CITY OF ALBUQUERQUE

**Re: Toyota Temporary Parking Lot, Grading and Drainage Plan
Engineer's Stamp Date 4-13-15 (C18D083)**

**RE: Grading Plan
Toyota Temporary Lot
C18D083
Albuquerque, New Mexico**

ENGINEER'S SEAL	AMERICAN TOYOTA TEMPORARY CONSTRUCTION YARD	DATE 2-25-13	SHEET # 21403
GRAPHIC SCALE	GRADING AND DRAINAGE PLAN	Ro Grande Engineering 1000 10th Ave N.E. Albuquerque, NM 87106	JOB # 21403

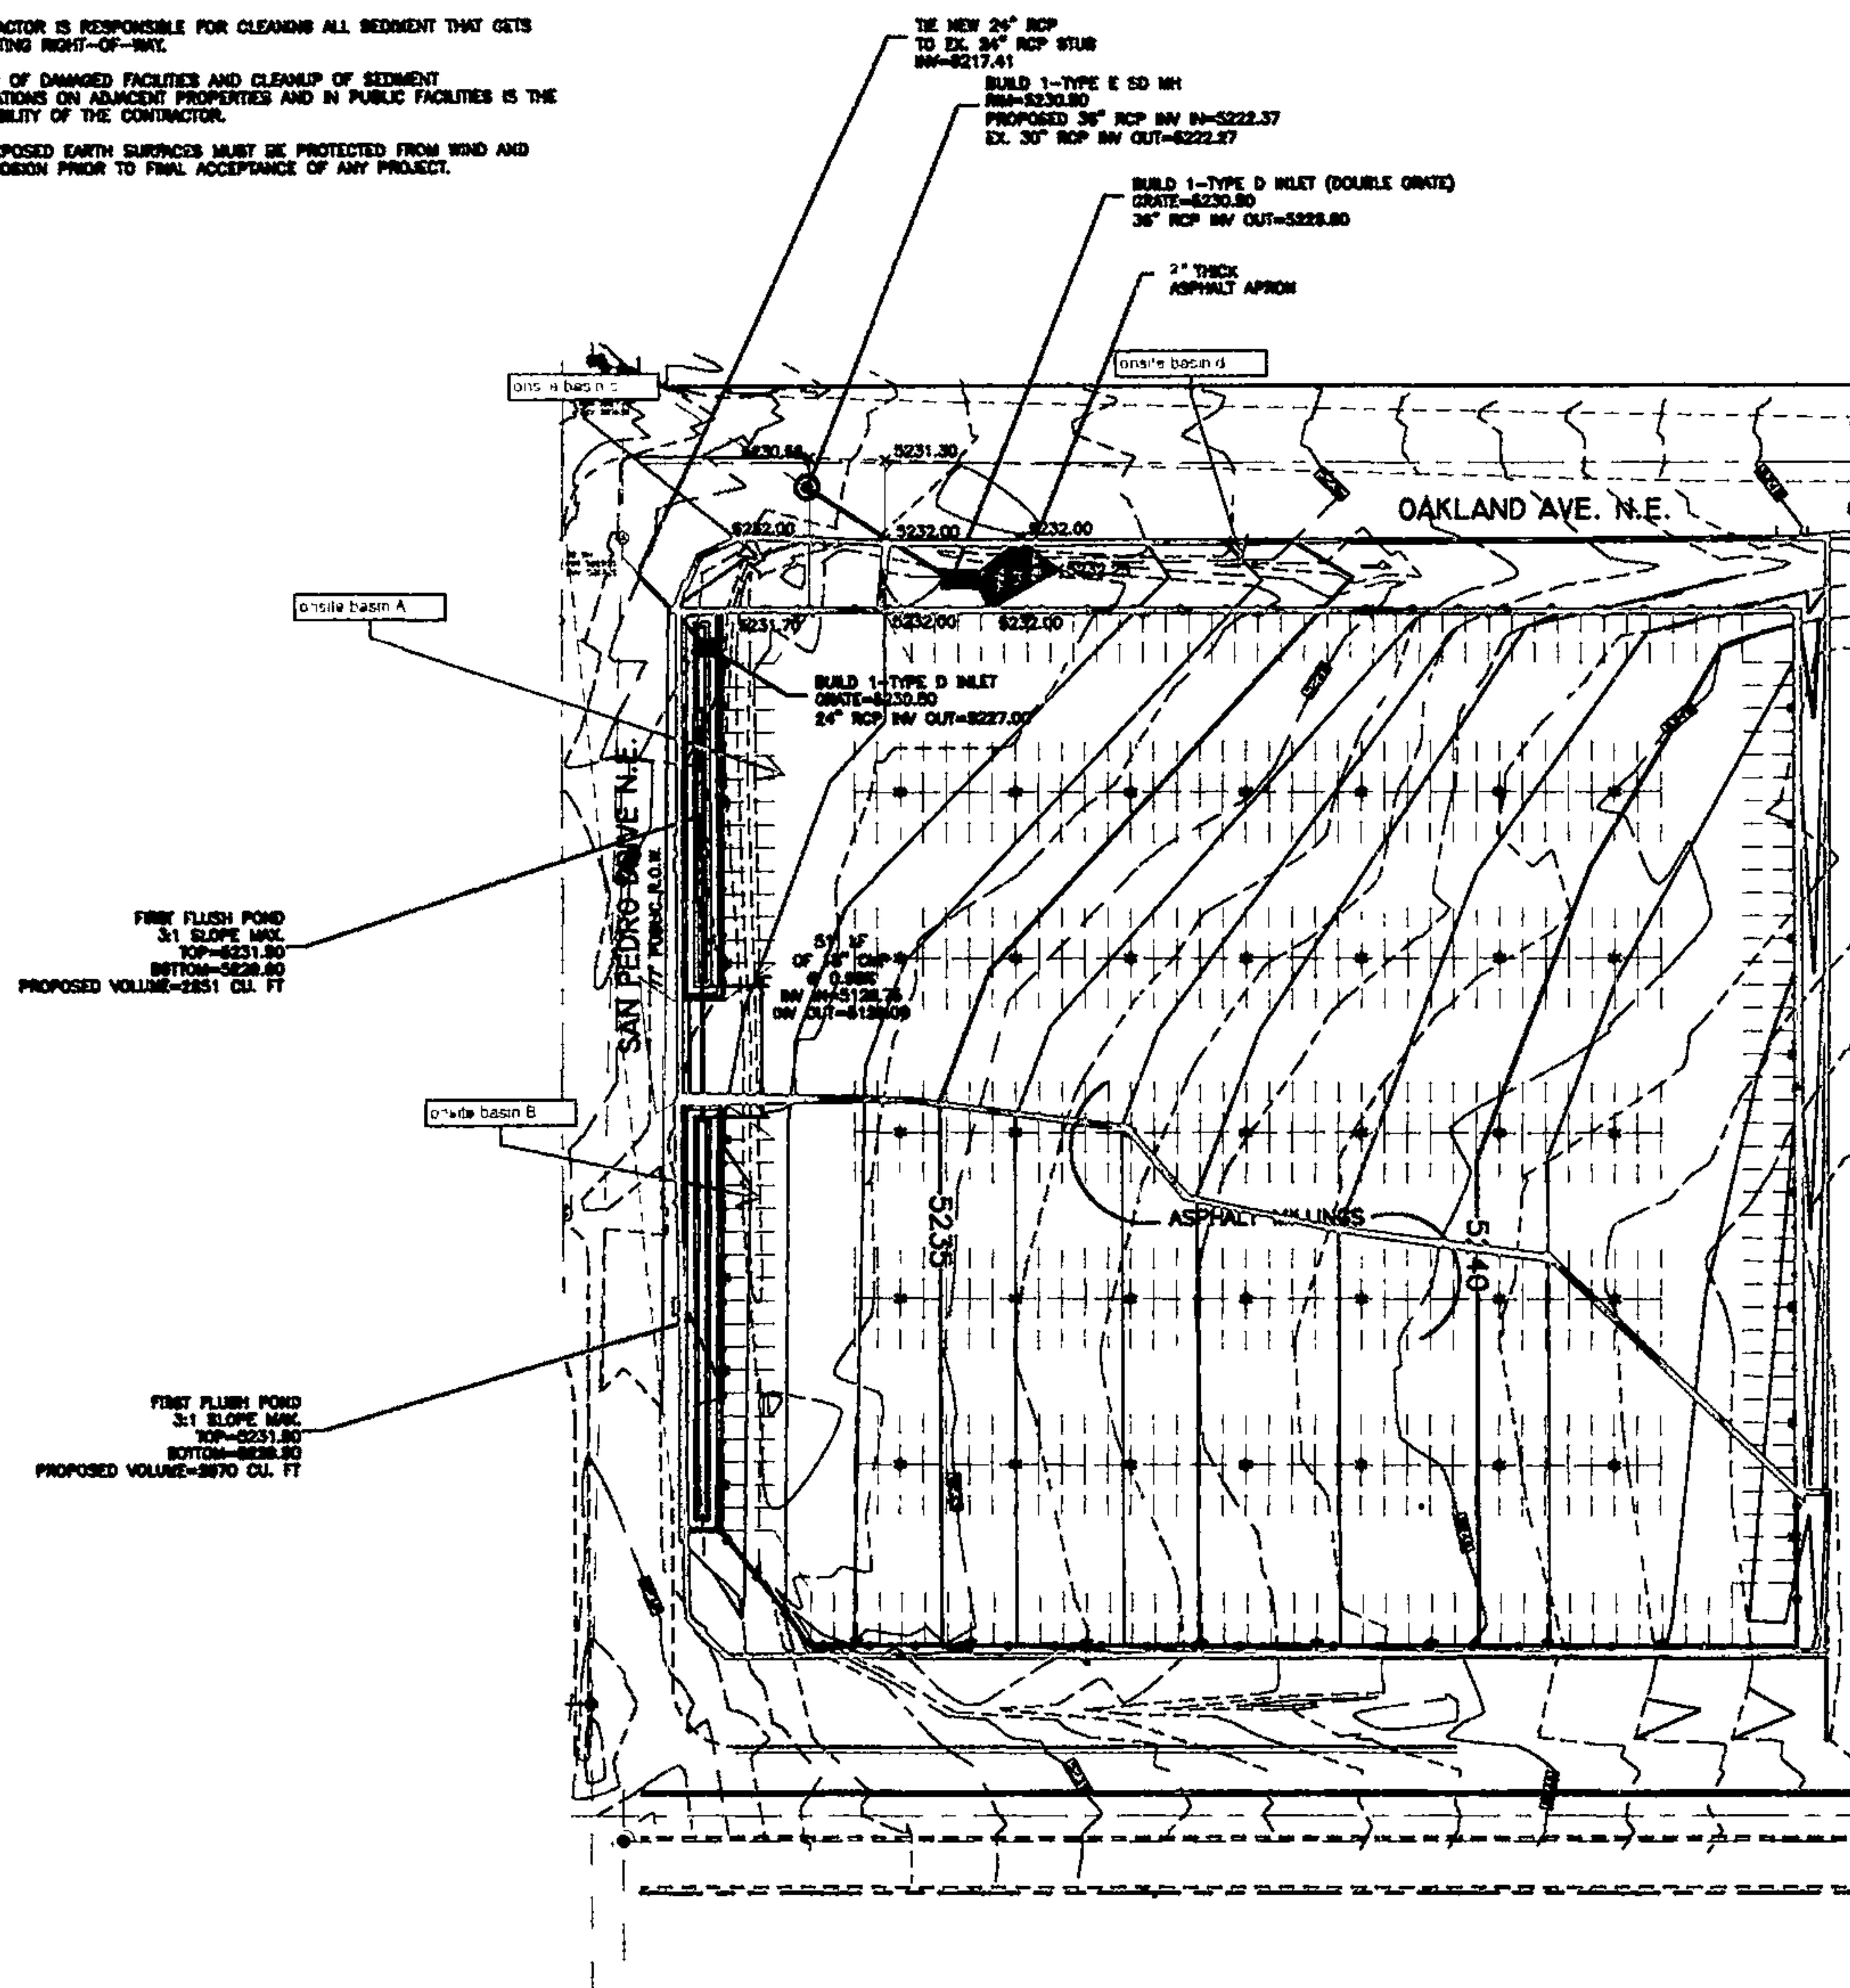
1. It appears an asphalt curb is needed to force the water into the first flush pond. In addition erosion protection is required where concentrated flows enter the ponds

2. Work within the right of way requires a work order

1. It appears a large portion of Onsite Basin A will drain to Oakland Ave ROW rather than to the northern onsite pond. Since the millings have already been laid, an asphalt curb could be constructed form the west edge of the millings east to the proposed 35 contour. Millings or similar should be laid where these concentrated flows will enter the pond to prevent erosion.
2. The work in the ROW will be built per the Work Order process, including the asphalt apron in Oakland Ave. Add a note to the existing build notes, that these times will be built per Work Order.

We have added the curb and called for rip rap to be placed at the location concentrated flows enter the ponds.

We have added this note to the plan set.
